## PRELIMINARY BCA ASSESSMENT REPORT

<b>To:</b>	Goodman		
<b>Attention:</b>	Richard Seddon	<b>Date:</b>	11/9/2008
<b>From:</b>	Tony Heaslip	<b>Sent by:</b>	Email
<b>Project:</b>	ARCBS – 17 O’Riordan St Green Square	<b>Project No:</b>	80313
<b>Copies:</b>	Goodman – Adrian Tesoriero	<b>Pages:</b>	11

The proposed development involves the construction of a processing facility for the Australian Red Cross Blood Service (ARCBS) containing a processing plant, laboratories, office administration areas, warehouse and basement car parking for 97 vehicles.

NORTH
GRAPHIC SCALE
0 4000 8000

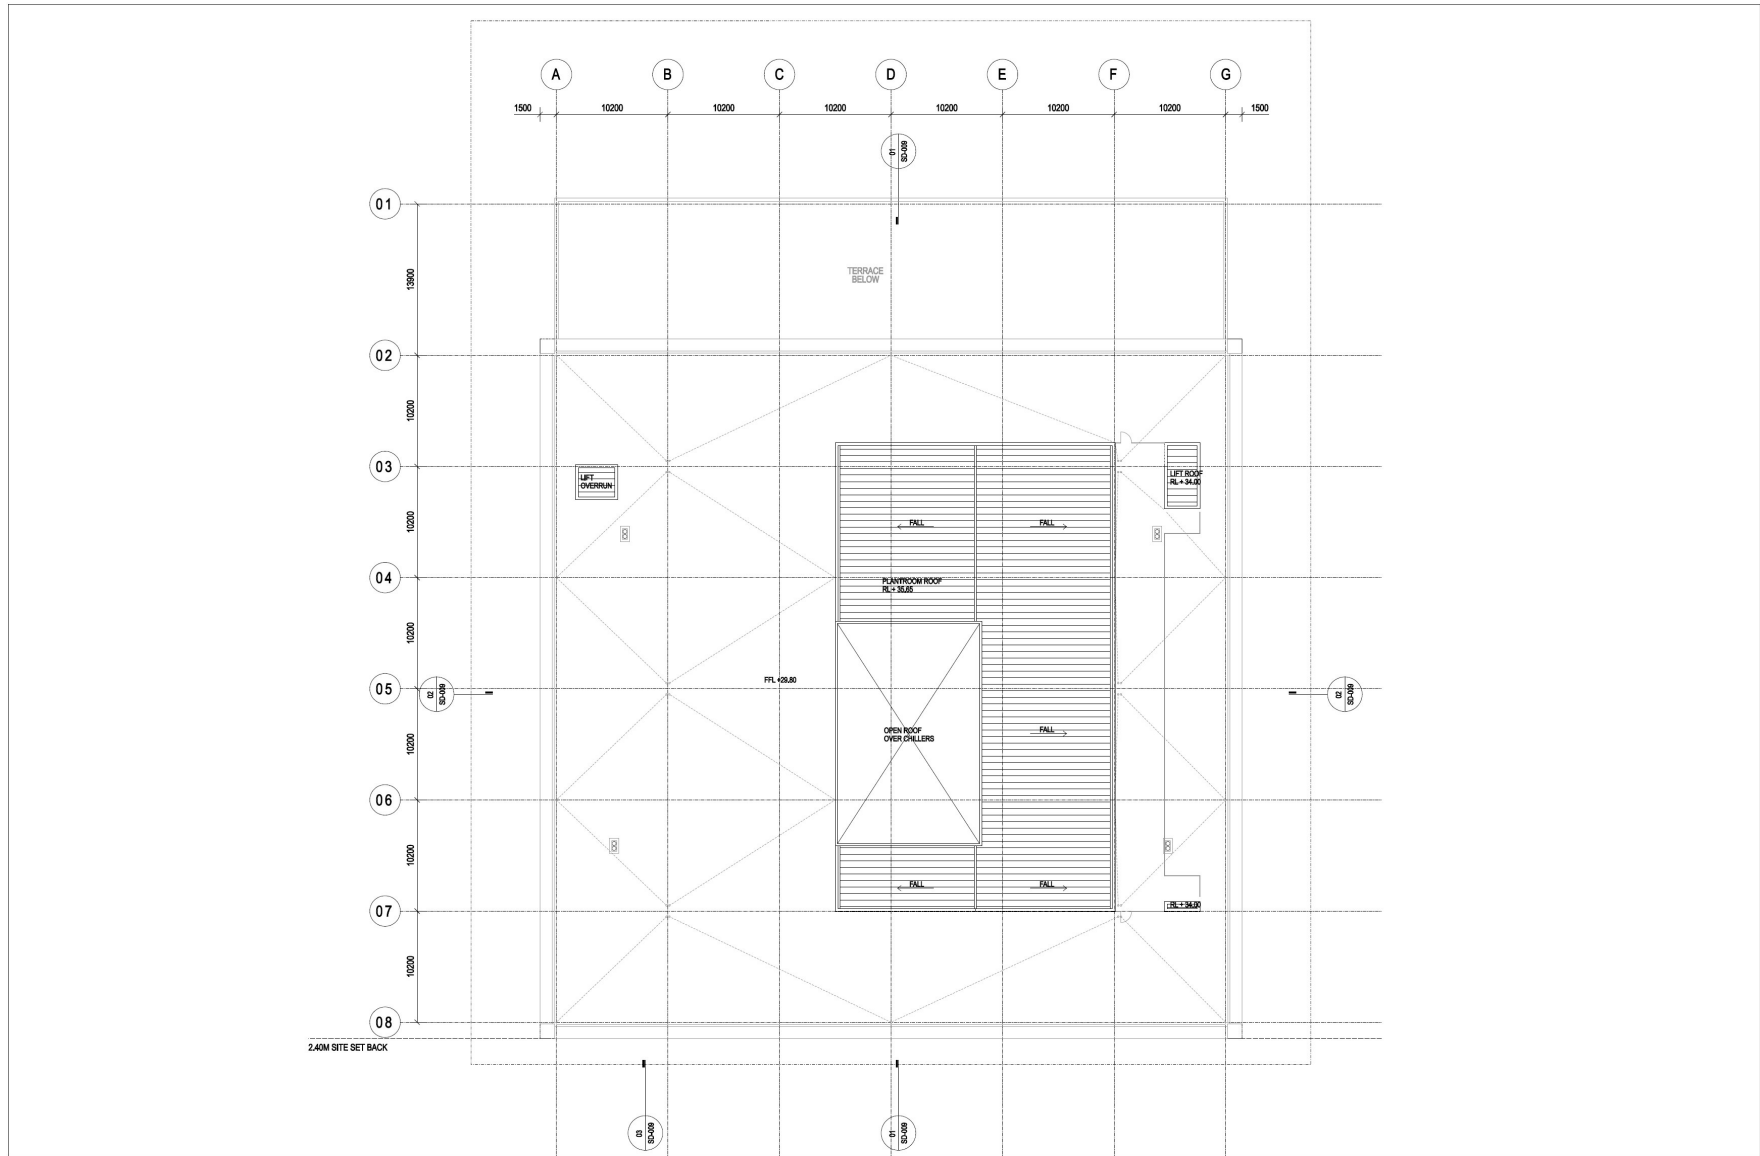
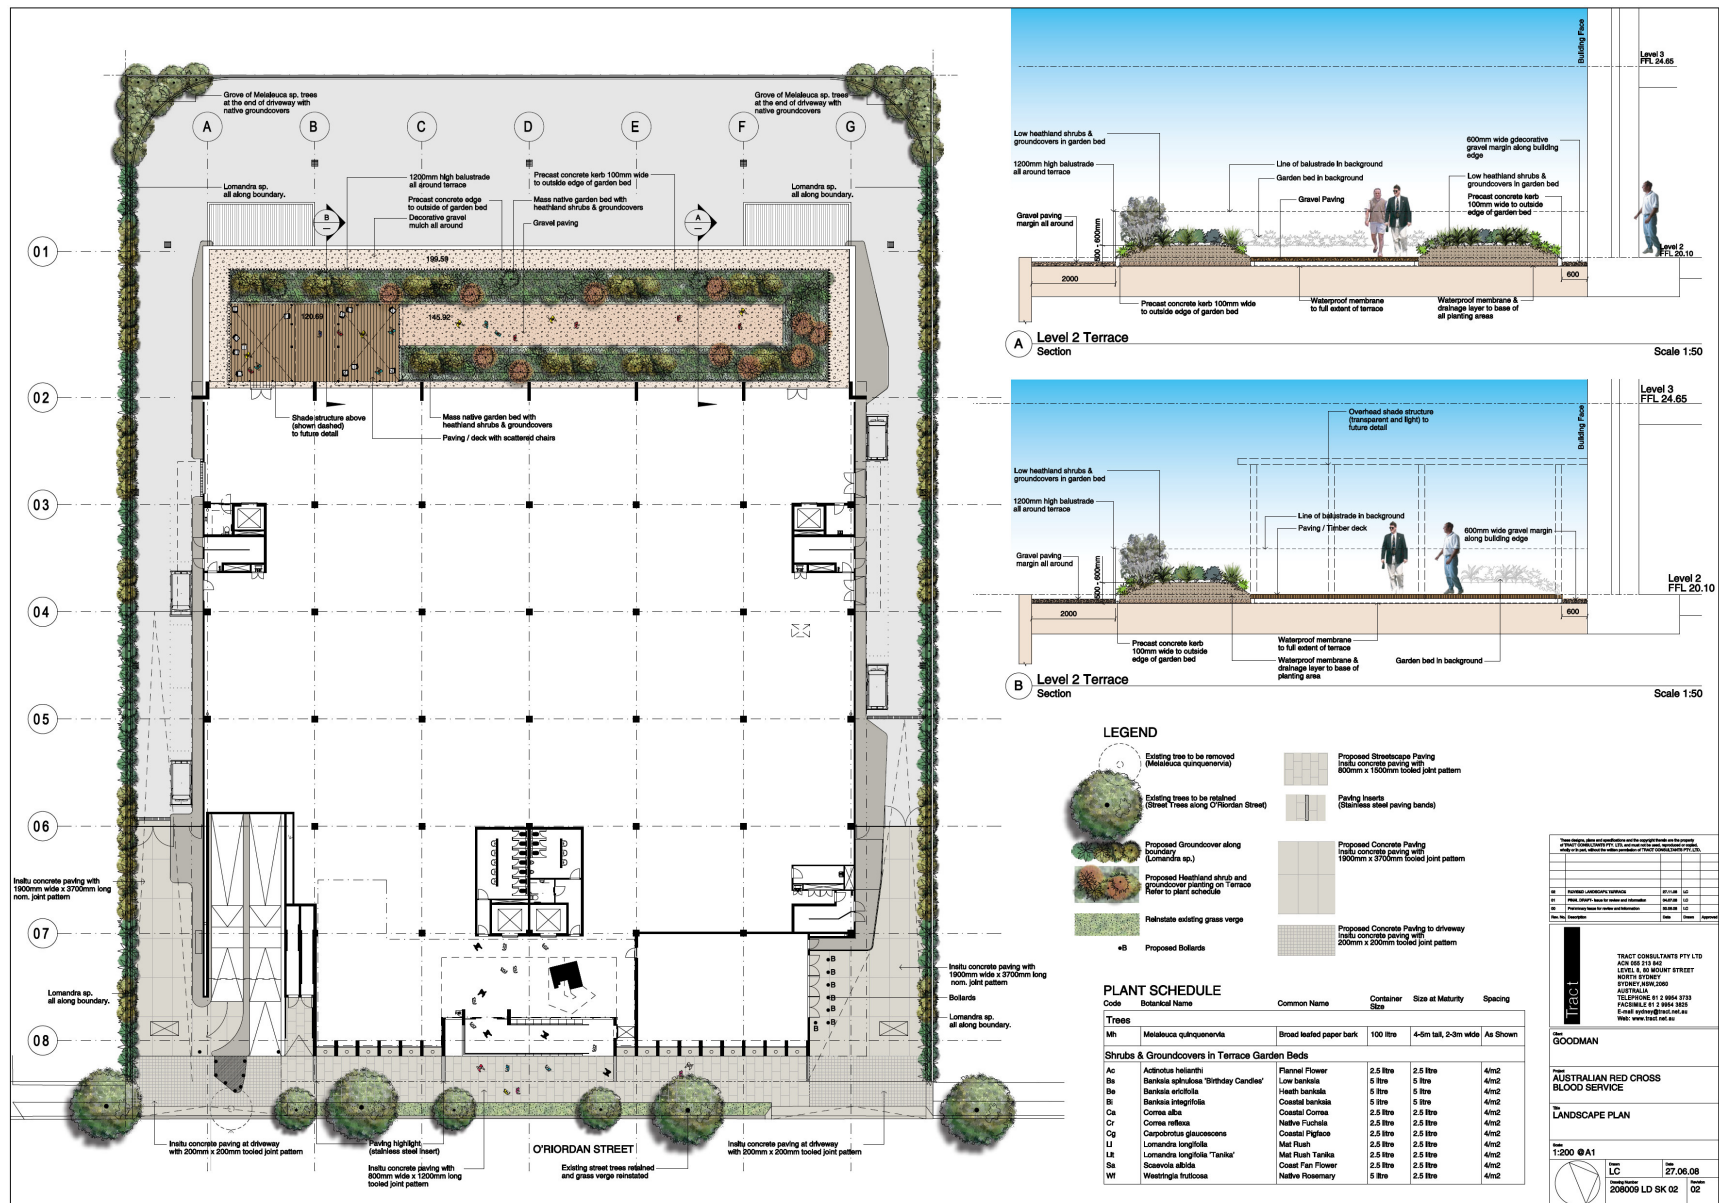
- Level 3 (incl. fitout):  
Distance to one of two alternative exits exceeds the prescribed maximum of 40m (51m proposed).
- Level 2 (incl. fitout):  
Distance to a point of choice to alternative exits exceeds the prescribed maximum of 20m (maximum 28m proposed from external Terrace).  
Distance to one of two alternative exits exceeds the prescribed maximum of 40m (maximum 50m proposed).
- Level 1 (incl. fitout):  
Distance to one of two alternative exits exceeds the prescribed maximum of 40m (maximum 45m proposed).
- Ground Floor (incl. fitout):  
Distance to one of two alternative exits exceeds the prescribed maximum of 40m (maximum 50m proposed).

- Level 3 (incl. fitout): Distance between alternative exits exceeds the prescribed maximum of 60m (maximum 76m proposed)
- Level 2 (incl. fitout): Distance between alternative exits exceeds the prescribed maximum of 60m (maximum 77m proposed)
- Level 1 (incl. fitout): Distance between alternative exits exceeds the prescribed maximum of 60m (maximum 66m proposed)
- Ground Floor (incl. fitout): Distance between alternative exits exceeds the prescribed maximum of 60m (maximum 88m proposed).
- Basement carpark: Distance between alternative exits exceeds the prescribed maximum of 60m (maximum 62m proposed).

The above exit travel distances non-compliance will be required to be addressed by an Alternative Solution which addresses BCA Performance Requirements DP4 and EP2.2.

The above non-compliances will be addressed by an Alternative Solution to address Performance Requirements DP4 and EP2.2.
